TREE LOCATION PLAN
CROSS STREET, WORSBOROUGH S70
NOT TO SCALE. JUNE 2026

Site Plan 1:200

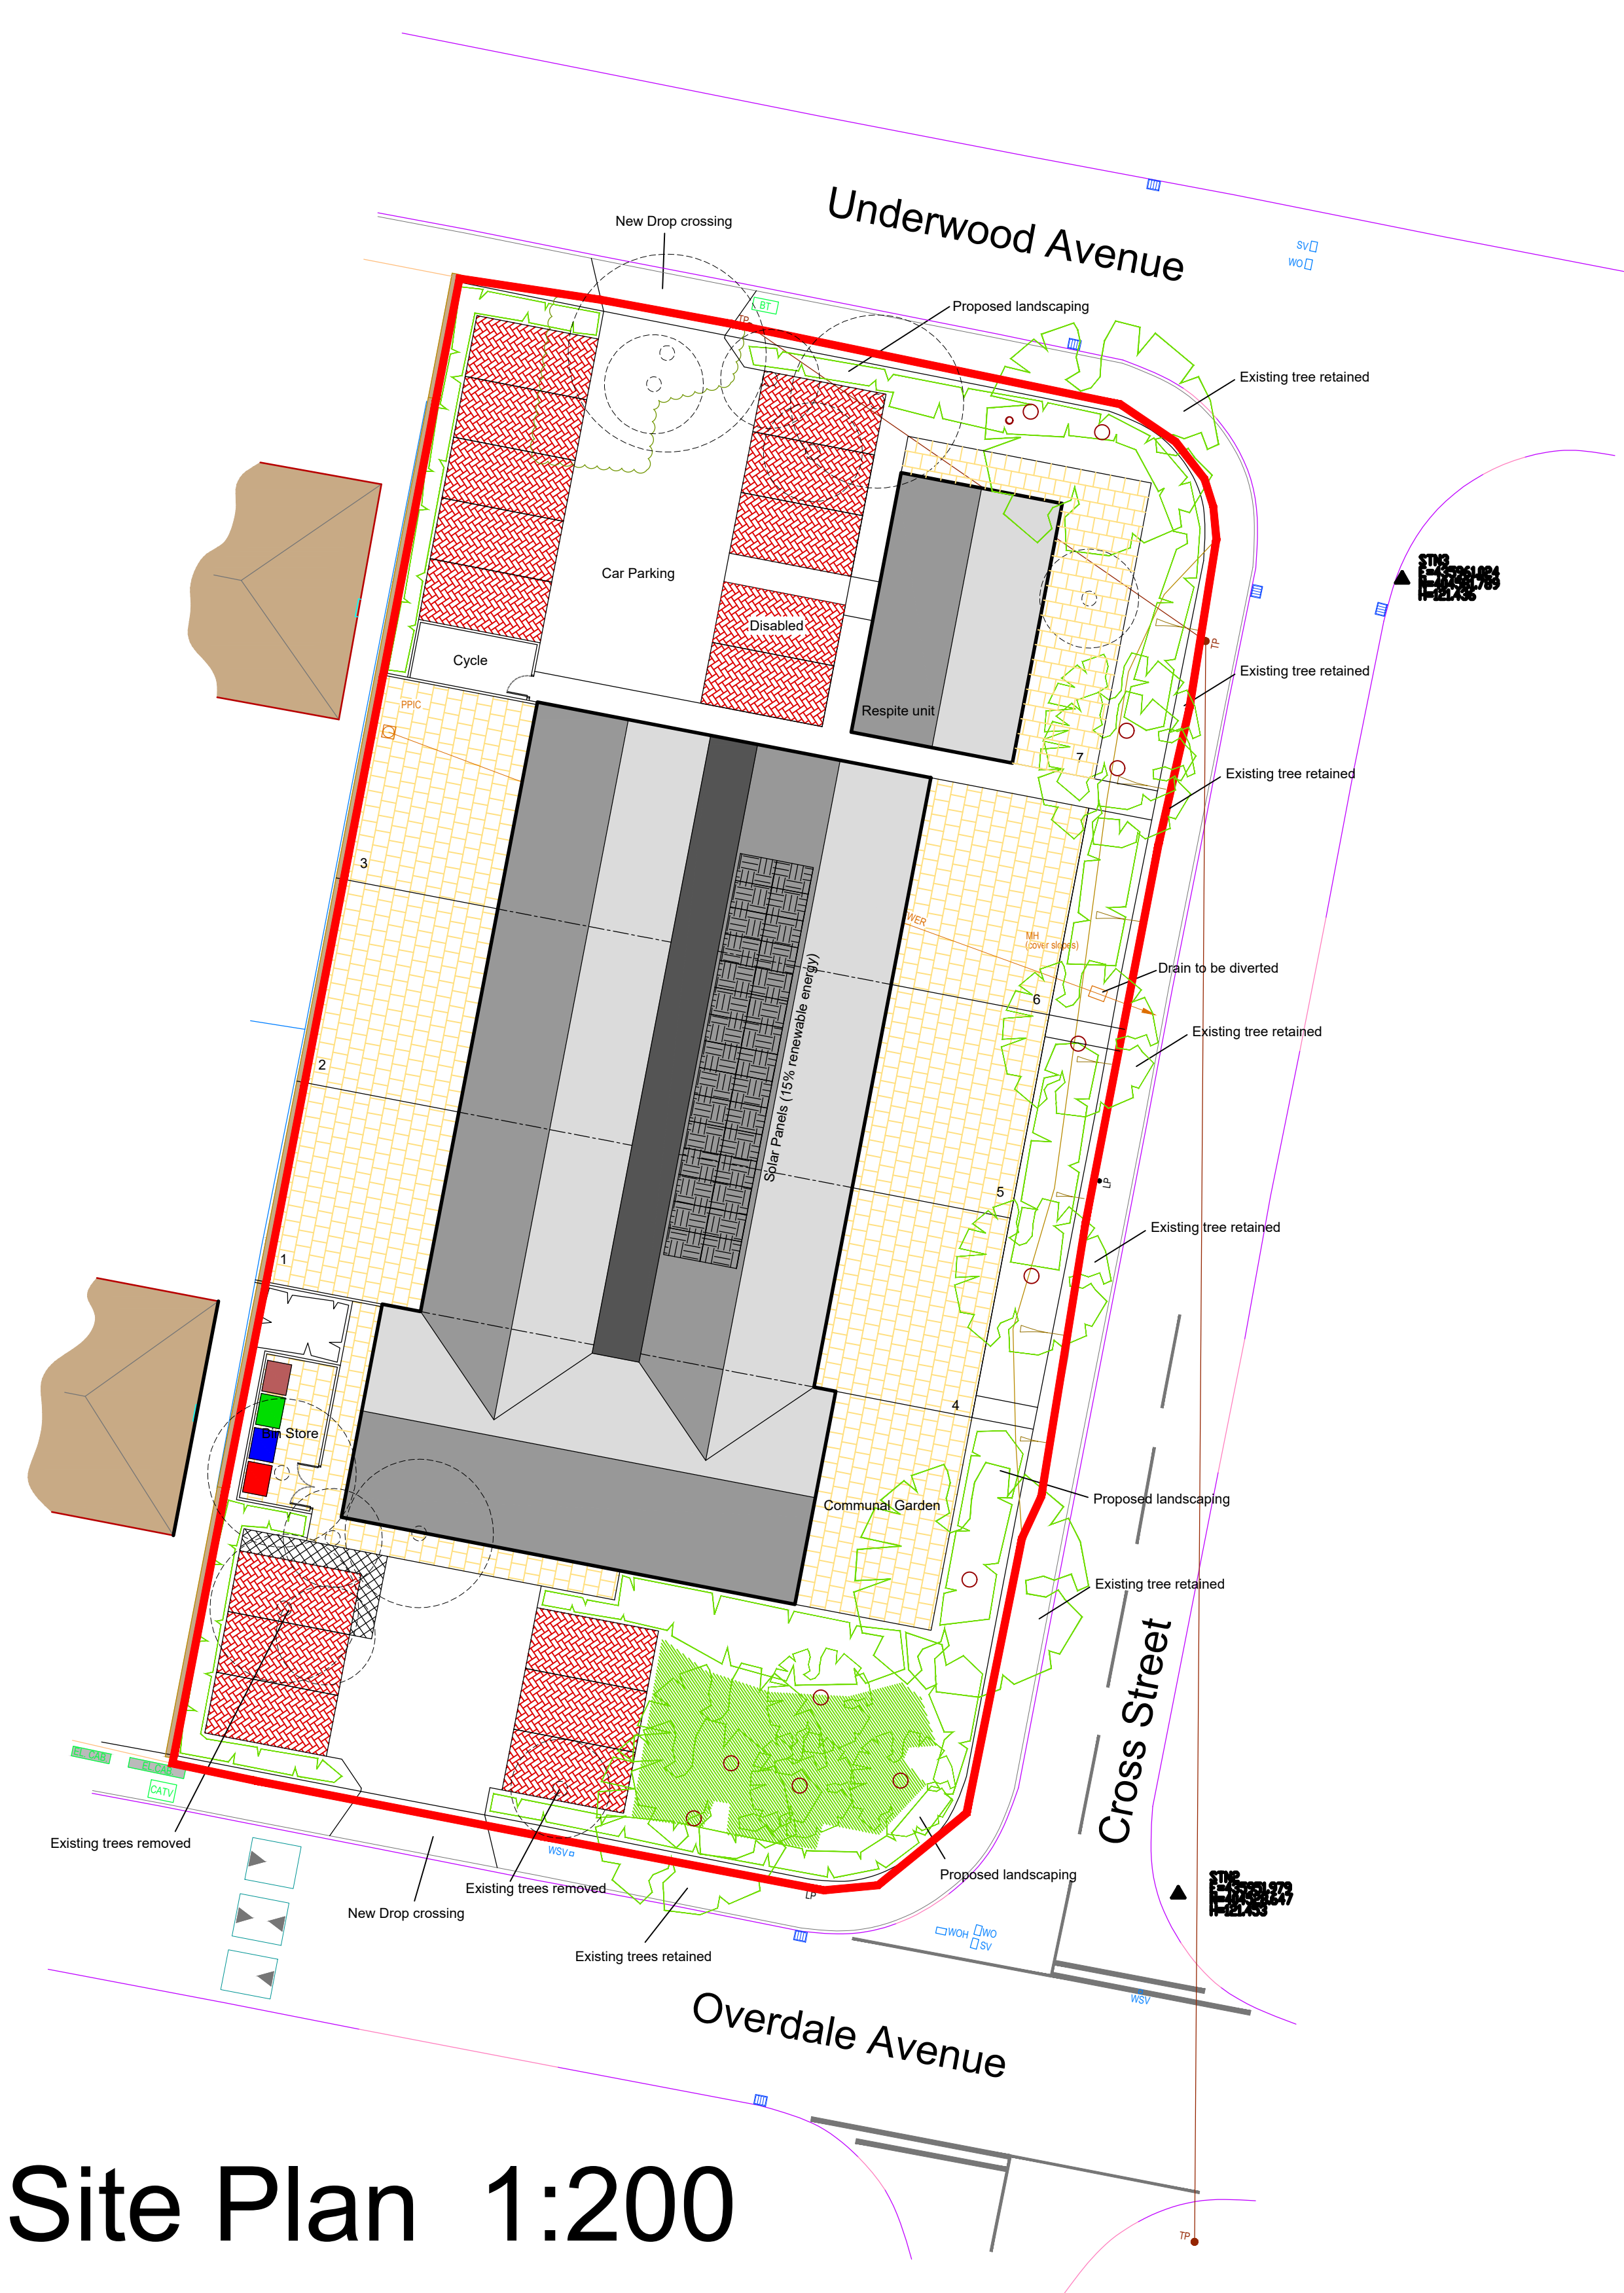
5.	Lime	This tree is coppice growth. There are several smaller stems that have grown from the stump of a now removed tree. this tree would require the same RPA as tree 3. There has been some significant soil disturbance at the base of this tree. (And with trees 6 to 8 as well.) It seems a new footpath has been installed alongside the highway and this has almost certainly caused root damage to the road side trees. The plan seems to call for the garden area to be paved, which means almost all of the RPA will be paved.

6.	Sycamore	Coppice growth, will require a similar RPA to tree 3, and if the garden is paved; as tree 5.
7.	Sycamore	More coppice growth, as tree 6. Additionally, there is a drain inspection chamber at the base of the tree. if this is to be relocated or modified, root damage is inevitable.

8.	Group	Mainly Sycamore, the largest is a similar size to tree 7, and will require a similar RPA. The plans do not require quite as much paving nearby as the previous trees, but the building will be within the RPA.

While the proposal shows all these trees retained, there isn't much that is worth retaining in group 4.

Sites like this are difficult. While the layout shows trees retained, in reality almost everything proposed will be within their RPAs and it's hard to see how the site could be developed without impinging one RPA or another. There is also the problem that works already undertaken must have impacted upon several trees' RPAs. The question that really needs to be asked is firstly "can steps be taken that will reduce the effect of the proposal on nearby trees?" and then "are the trees so important that they should be allowed to stand in the way of an important development?"

There are systems of building near trees that can mean there is minimal excavation, but there will always be some root disturbance and even the altering of soil levels and the rain water that reaches the soil, can affect nearby trees. I also note that this proposal contains several areas where it seems hard landscaping is to be installed (presumably to accommodate the eventual residents), which might also affect established trees. My point here is that we could go to some lengths to utilise low impact building systems, but these are not bound to be successful, and where trees are already compromised, the chances of success are further reduced.

Taking the above into account, my advice is that the best way of ensuring that this site makes a contribution to the local landscape in the future is to remove them all and replant when development work is over. I don't think we can avoid the fact that nearly all the trees are already compromised by ground works and susceptibility to disease (the Ash) so the best option is to remove and replant.

In my opinion planting the site with Hornbeam trees in place of 4, 8, and 10 would be pragmatic, perhaps with mixed (native) hedging along the boundaries. Hornbeam is a native species and grows well in urban areas. It is also not particularly disease prone and the Forestry Commission website does not have any alerts about impending diseases. Mixed native hedges are much more desirable than Privet or Leyland Cypress and invariably prettier as well.

1. The most sensible option for this site is to remove all the existing trees, and replant once building work is complete.
2. Although it would be feasible to try and keep some of the trees, many have already suffered root damage, and further disturbance is likely to lead to decline.
3. The worst-case scenario here is that we try to keep trees and then end up watching them decline slowly over the coming years. Planting new trees in good topsoil, in positions specifically created for growing trees and hedges, is likely to give the best long-term outcome.
